Application no: H02-0450-10

Description: Details submitted relating to Conditions 2, 3, 4, 5, 6, 7, 9, 13, 14, 15, 16, 17 and 18 of H02-0657-08)

Location: 61 South Street
Crowland
Peterborough
Cams
PE6 0AH
PE6 0AH

Amendment: Side hung casement windows
(dwg. nos. 844-01-01-PD01D and 844-01-01-PD02D)

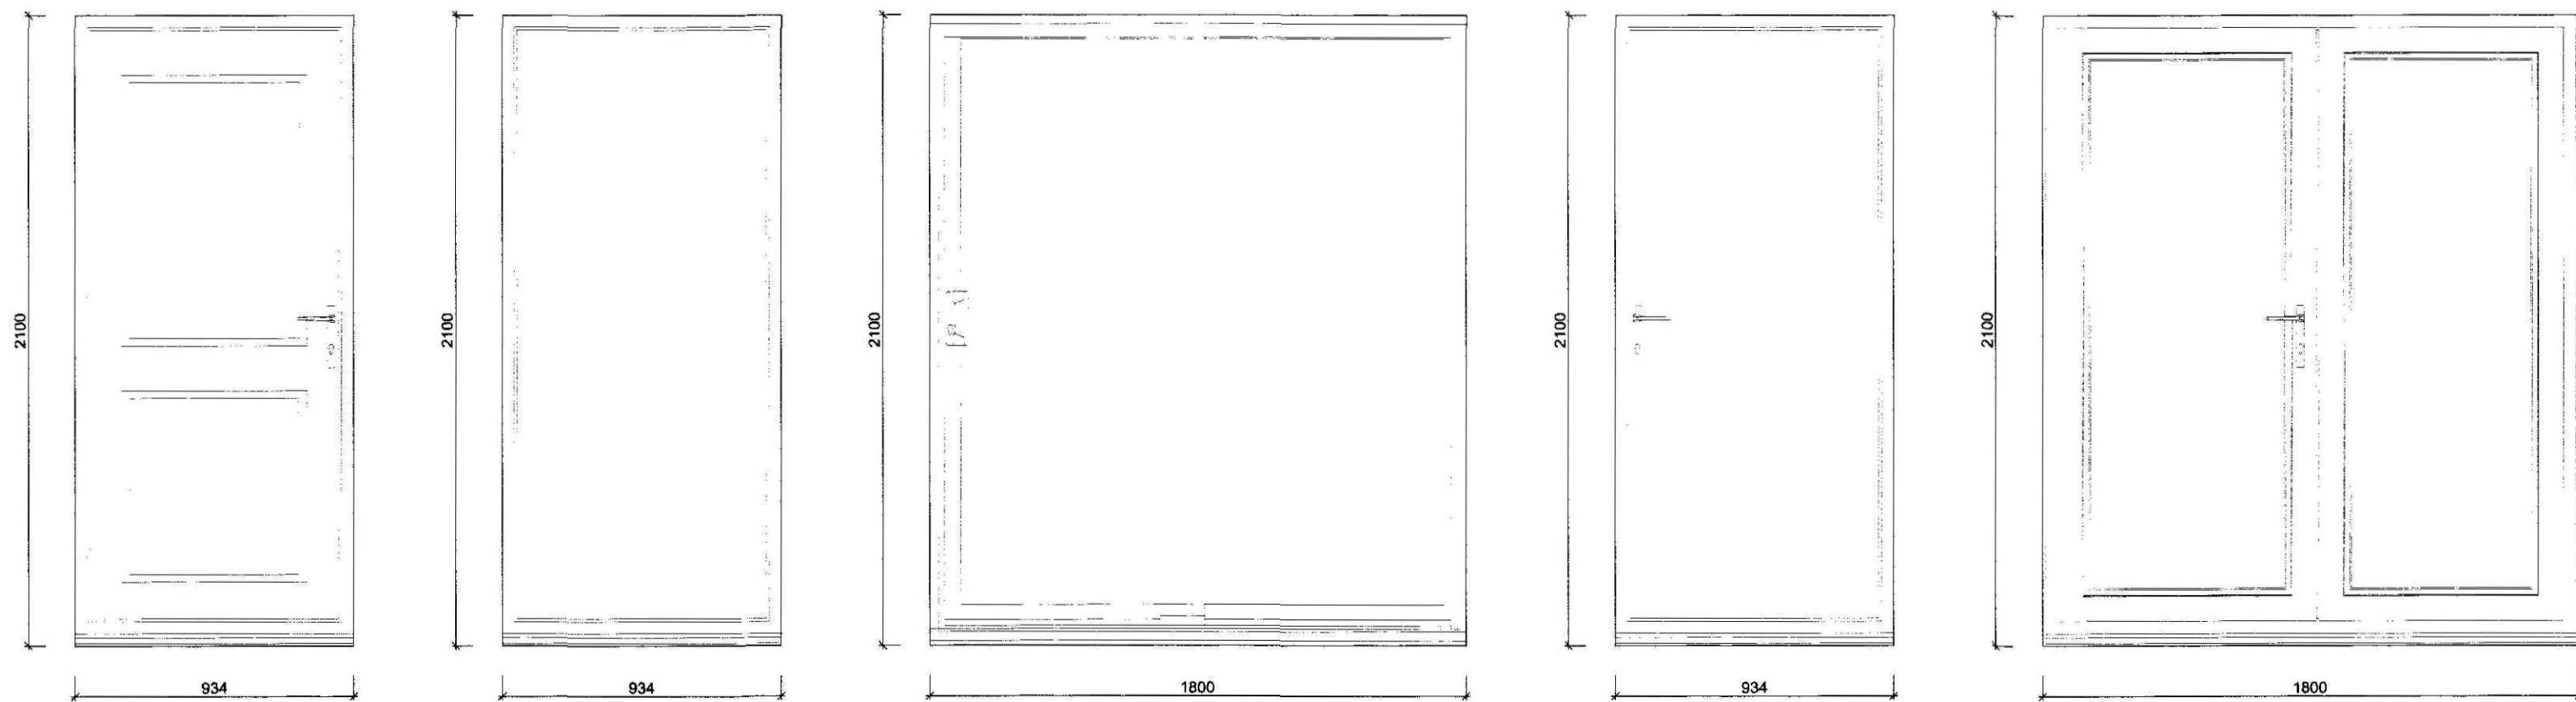
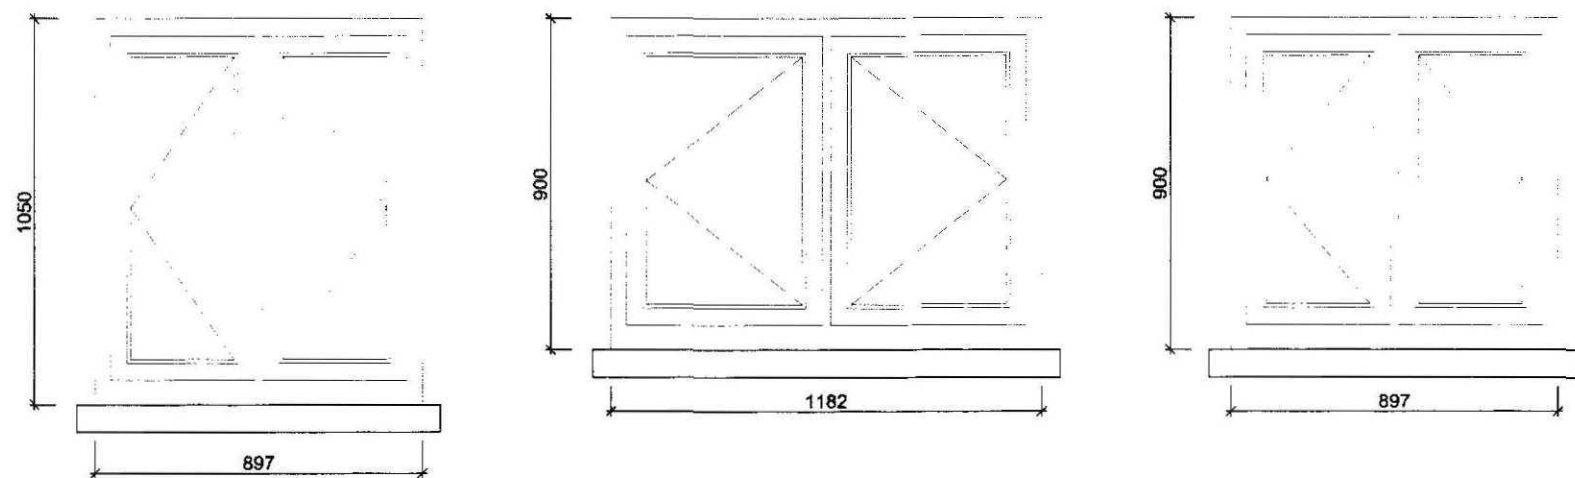
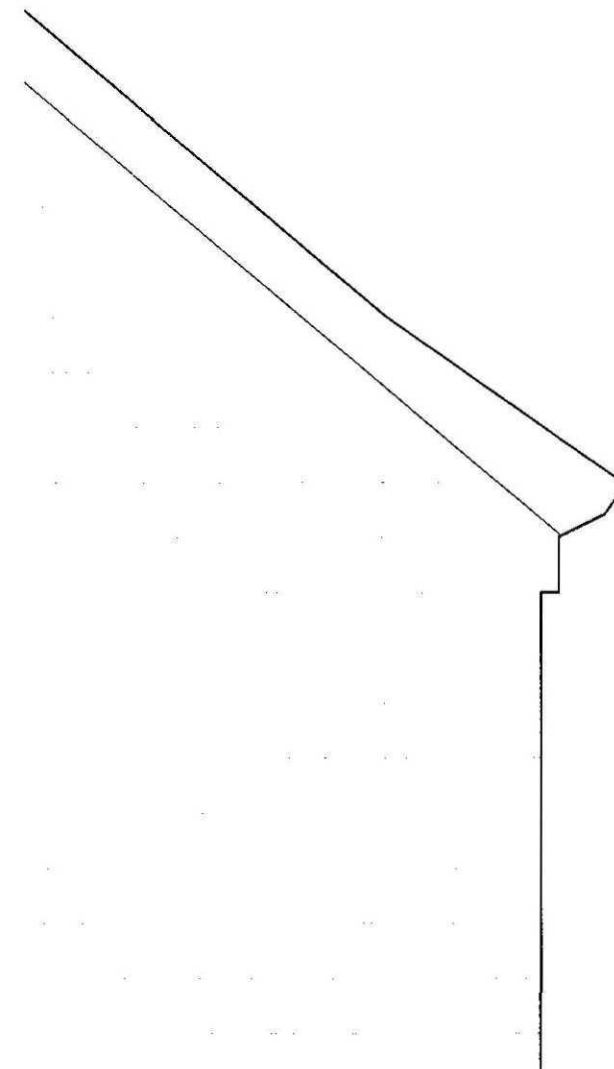
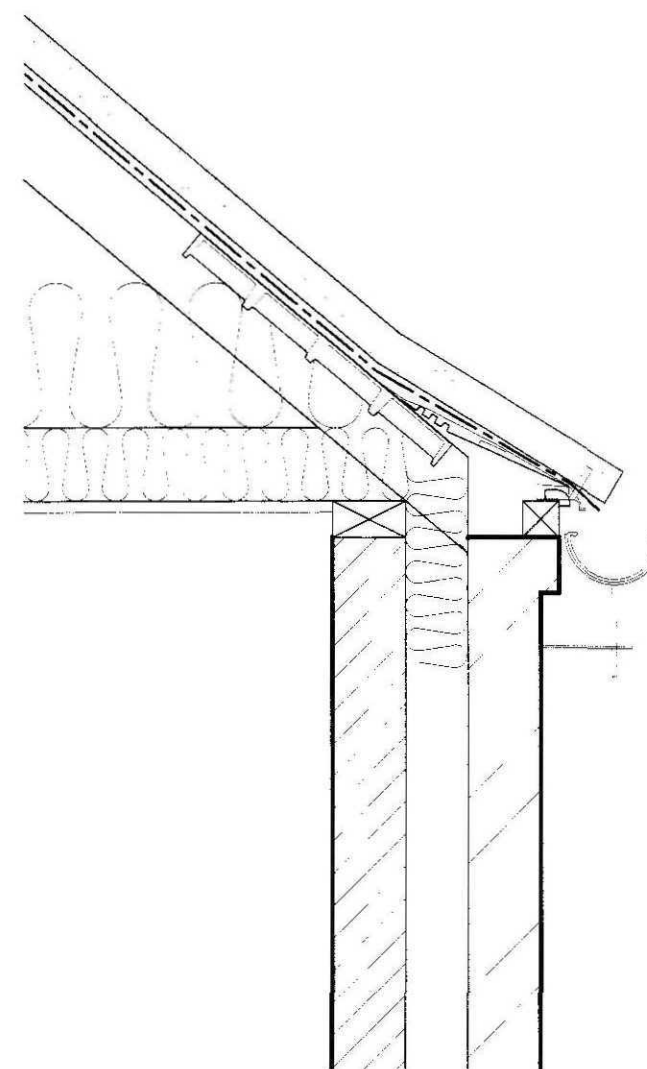
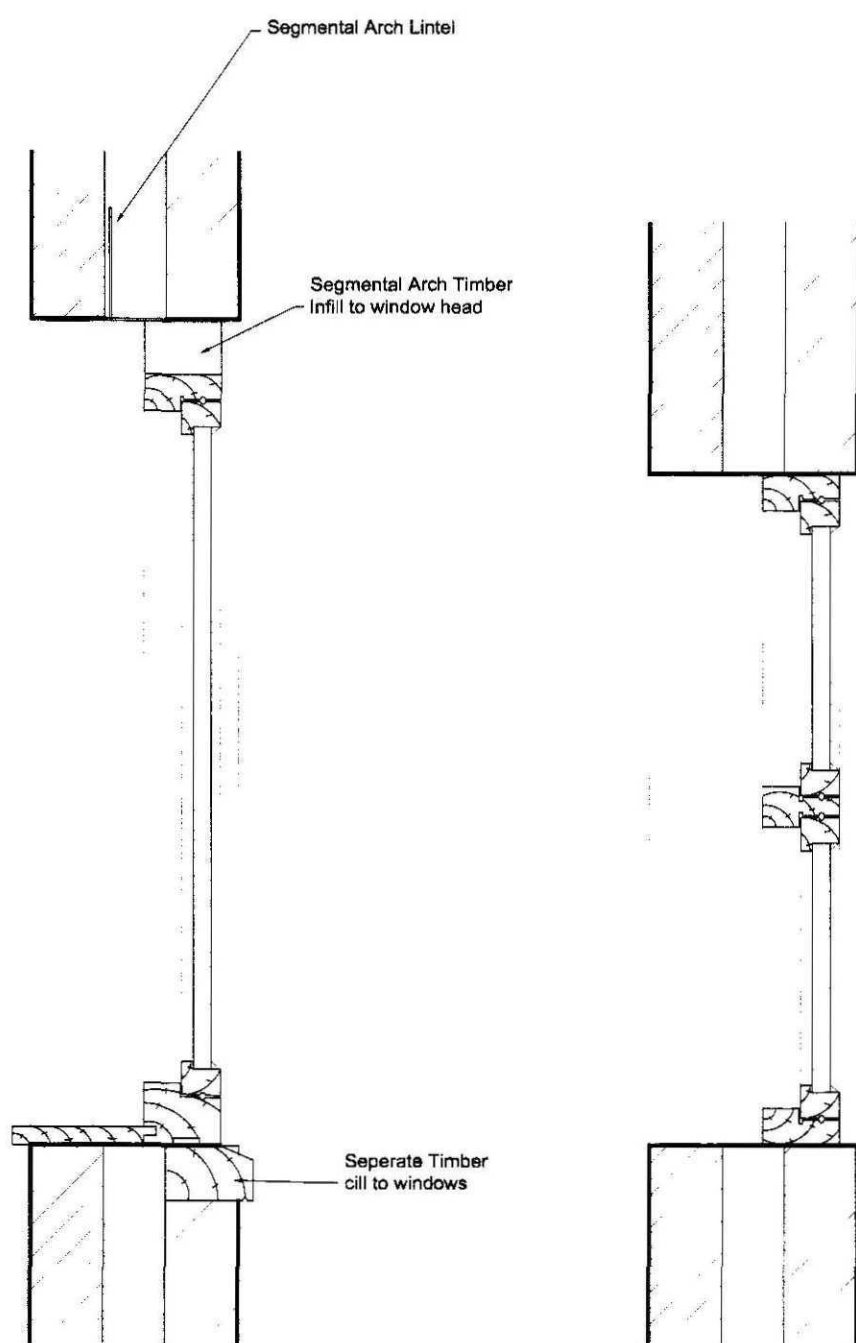
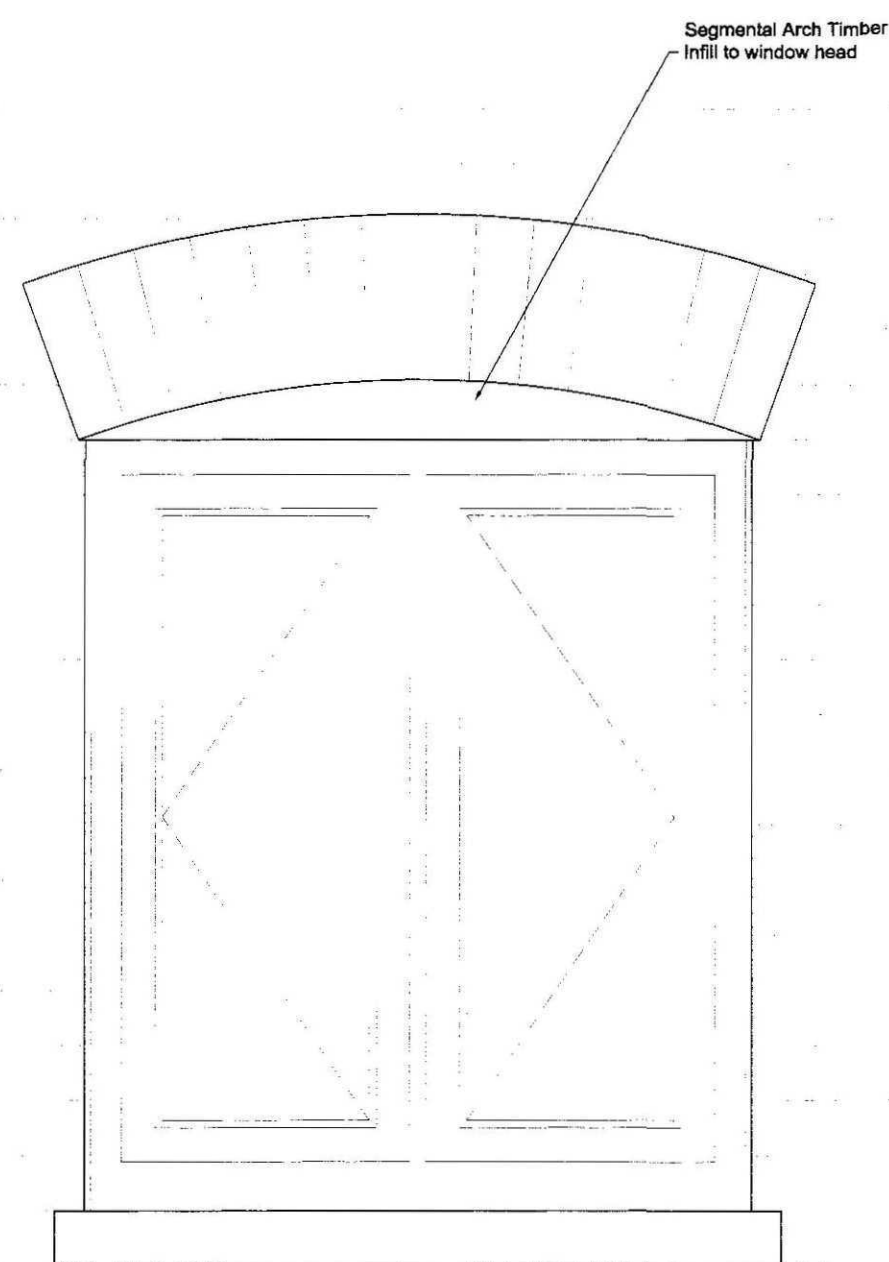
Attached are the agreed details for the two plots with the addition of the note stipulating the use of arch lintels.

Also attached are the revised windows for the replacement. I hope these are in accordance with our discussion.
